City of Portland, Maine - Building or Use Permit Application

Proposed Project Description:
Amend permit # 04-0020 for further structural flooring & roof work & 2 partitions

RE: Phase II Structural Analysis and Design – 3d Floor
46 Clifford Street, Portland, Maine
Resurgence Project Number 04-001

**3 DETAIL: RAFTER BASE ANCHOR**

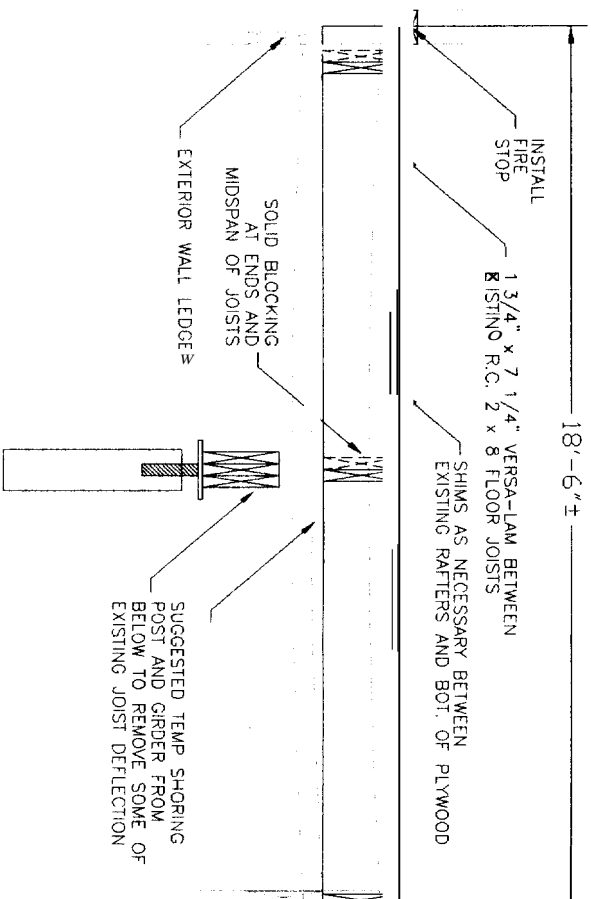
the bottom 13 feet of the existing rafters. Additionally, you should install ¼” plywood along the knee wall, and install Simpson H5 rafter ties along the inner face of the wall top plate.

# roof framing

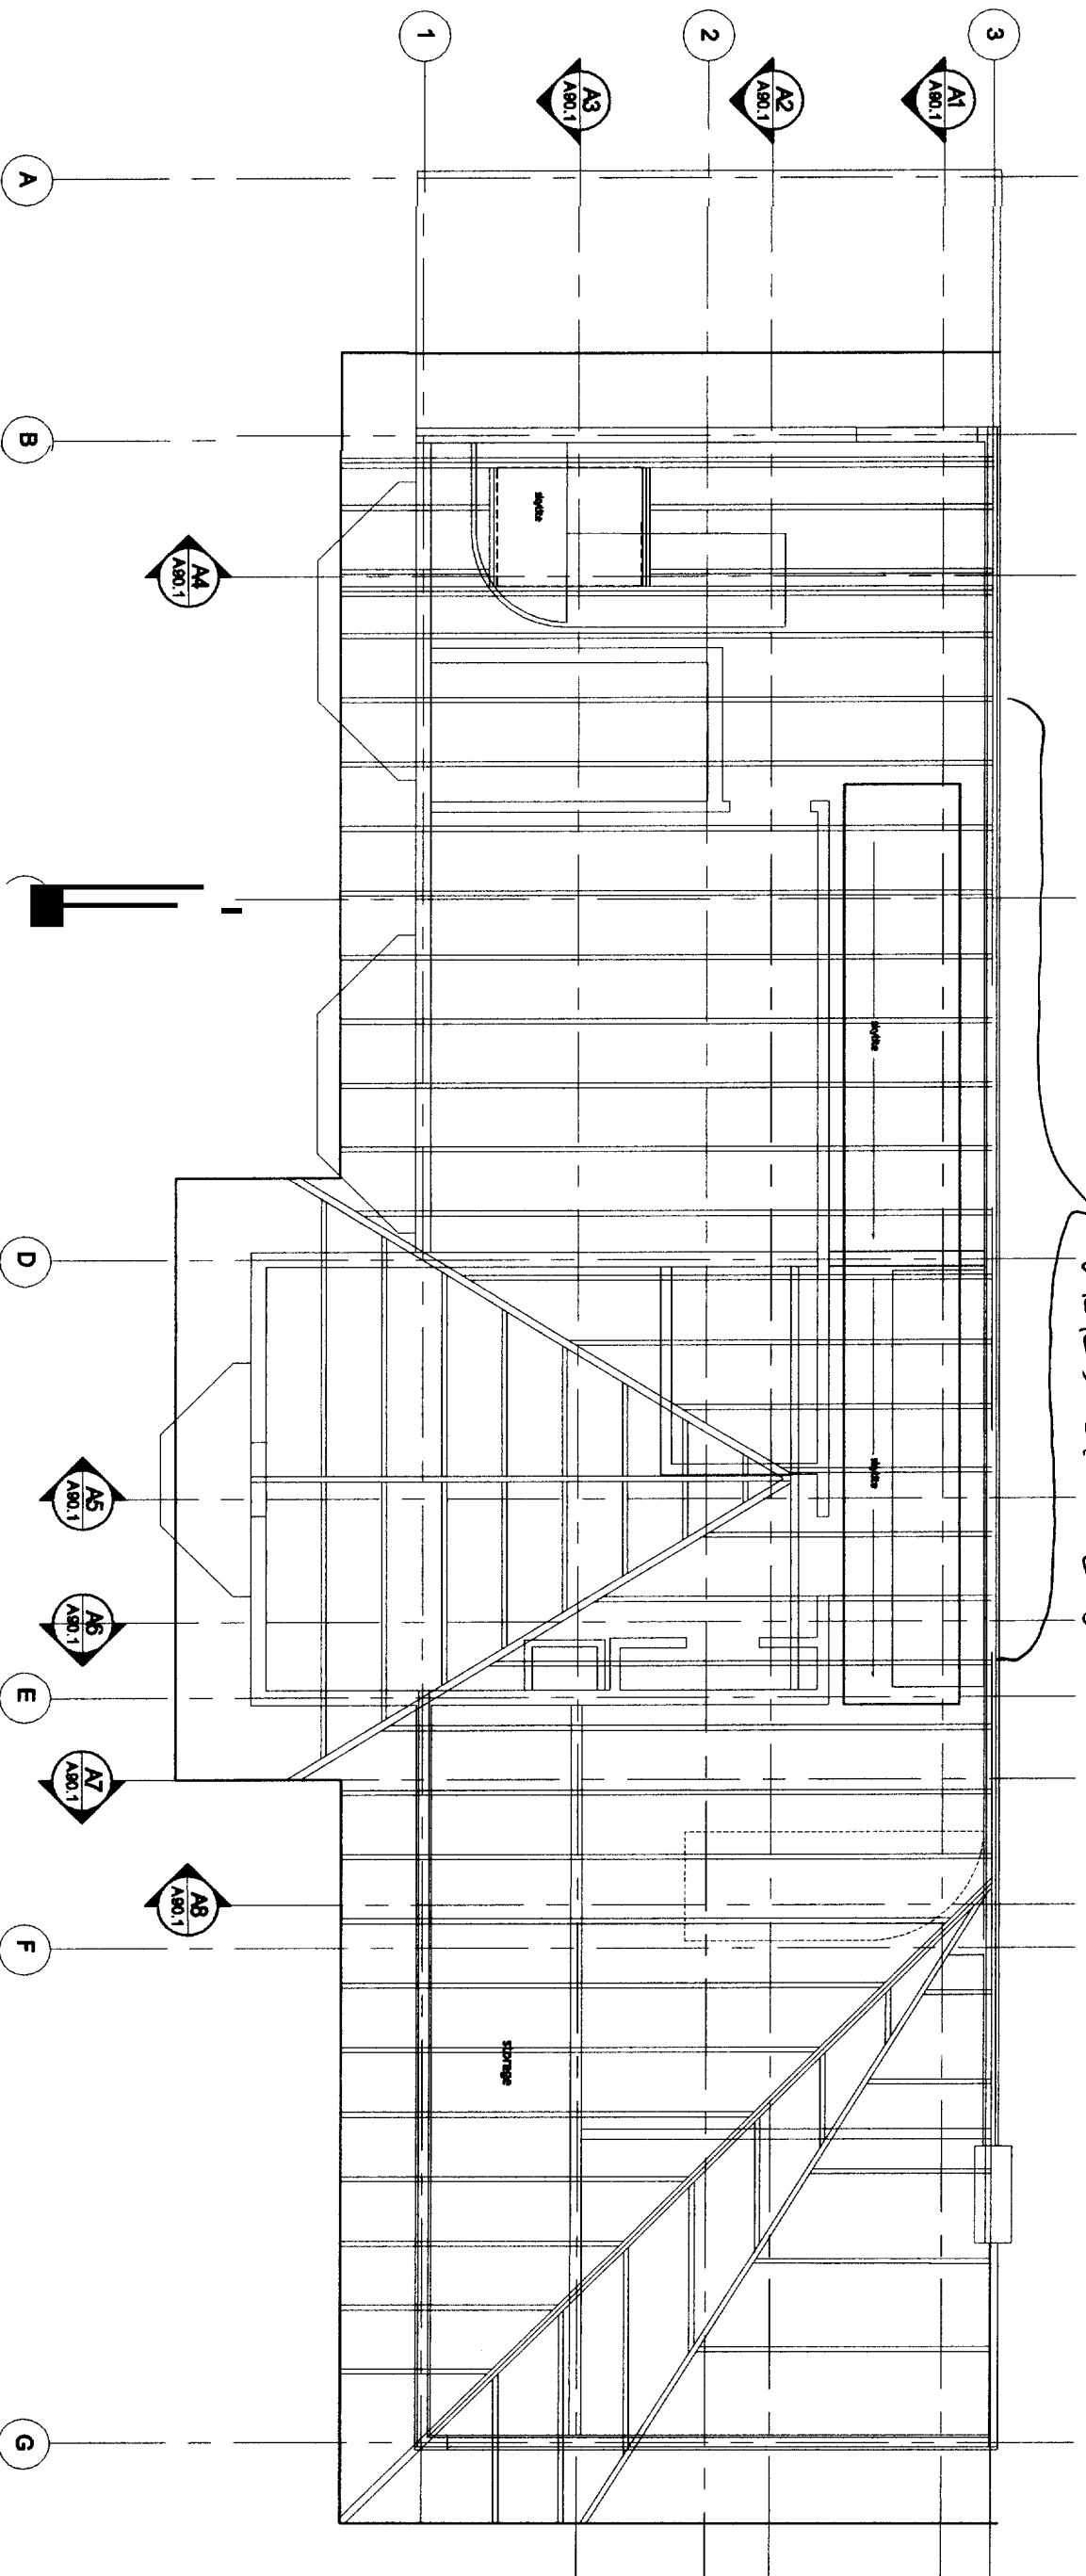
1. Strengthen the existing roof rafters with 1 ¾" x 7 ¼" Versa-Lam members. An economical way to strengthen the rafters is to place a sistering piece of Versa-Lam along
